CITY OF ALBUQUERQUE

Planning Department

Re: 8009 Victoria NW
Request Permanent C.O. - Denied
Engineer's Stamp dated: 9-12-17 (E10D037)
Certification dated: 6-8-18

**Lots 12, Block 6  
Volcano Cliffs Subdivision, Unit 5  
GRADING PLAN**

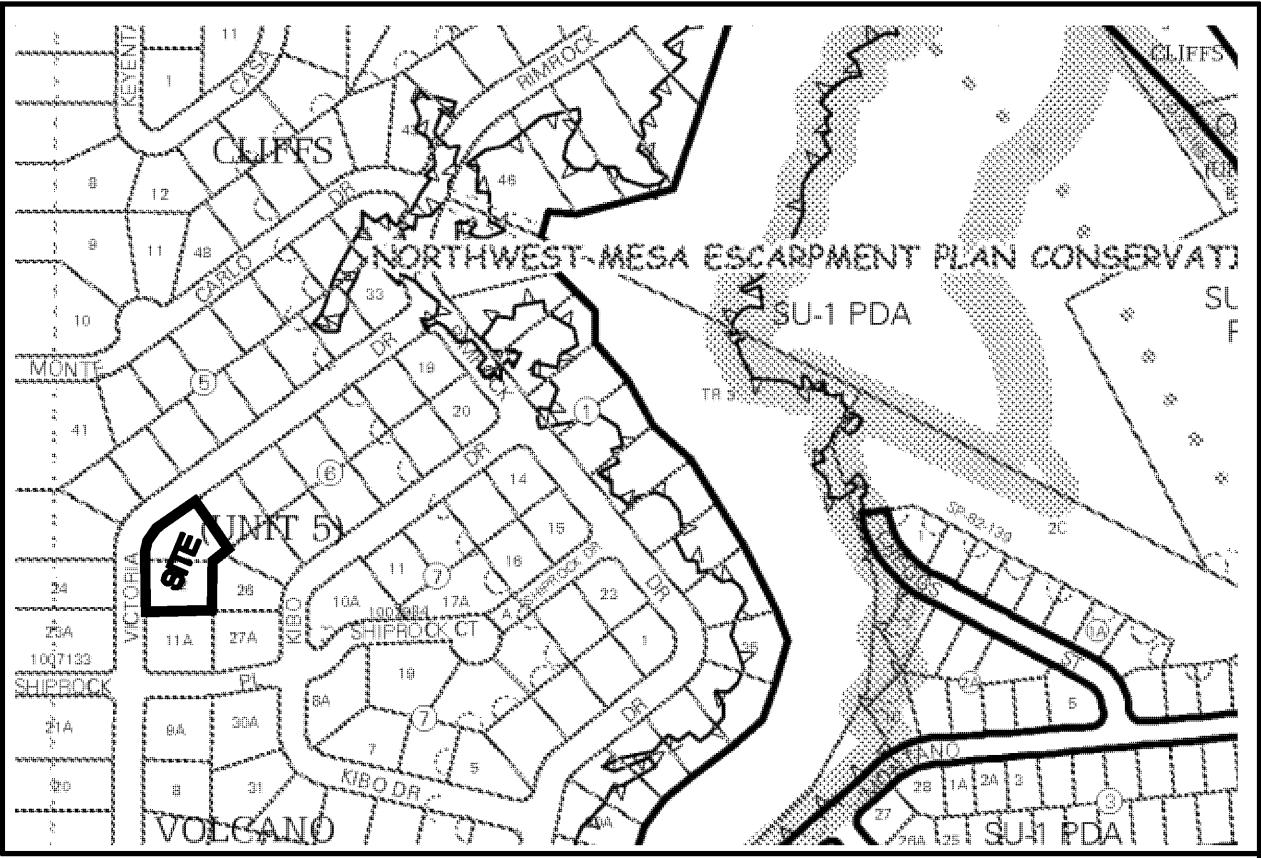
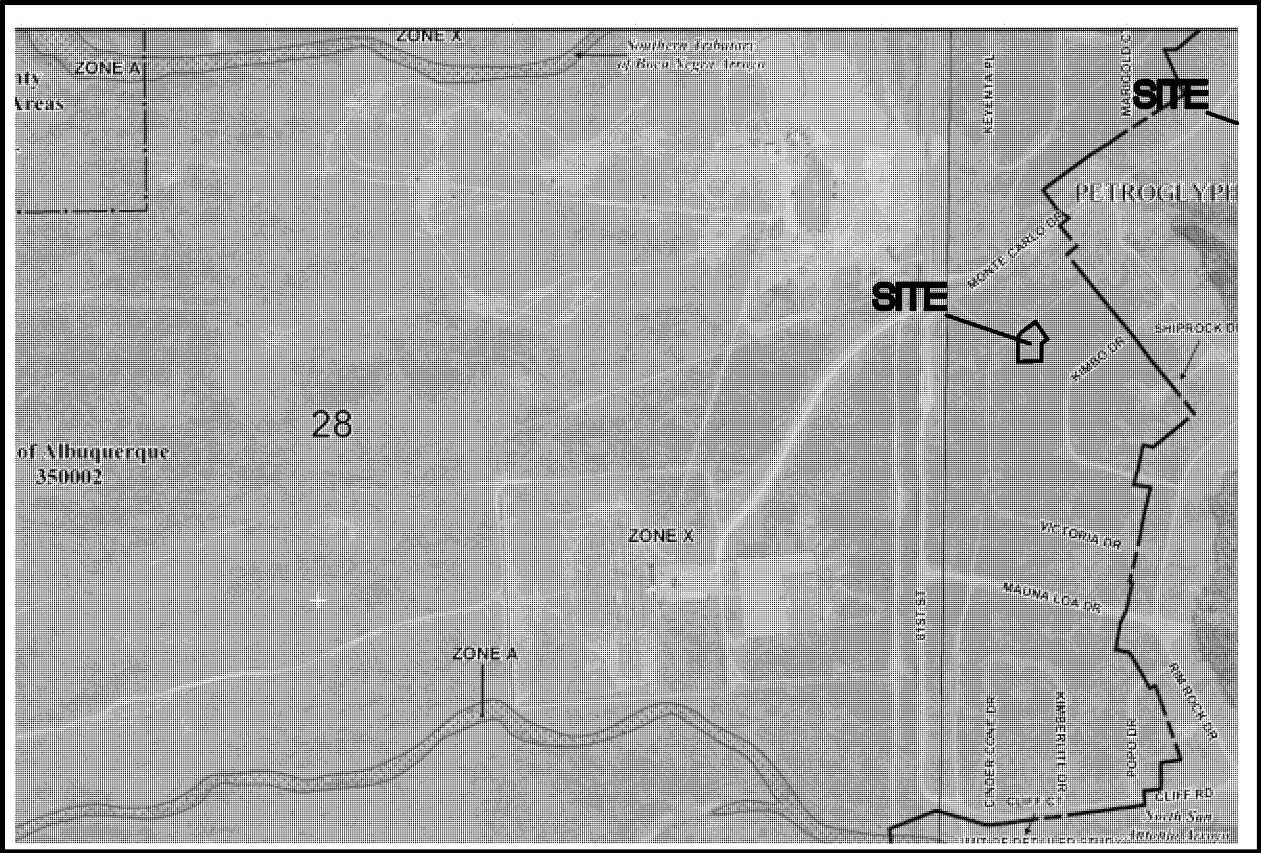
- Remove all concrete and debris in and around the site.
- Fill in the pond in the rear yard to its approved level.
- Remove the ditch in the rear yard. A 6" swale is sufficient.
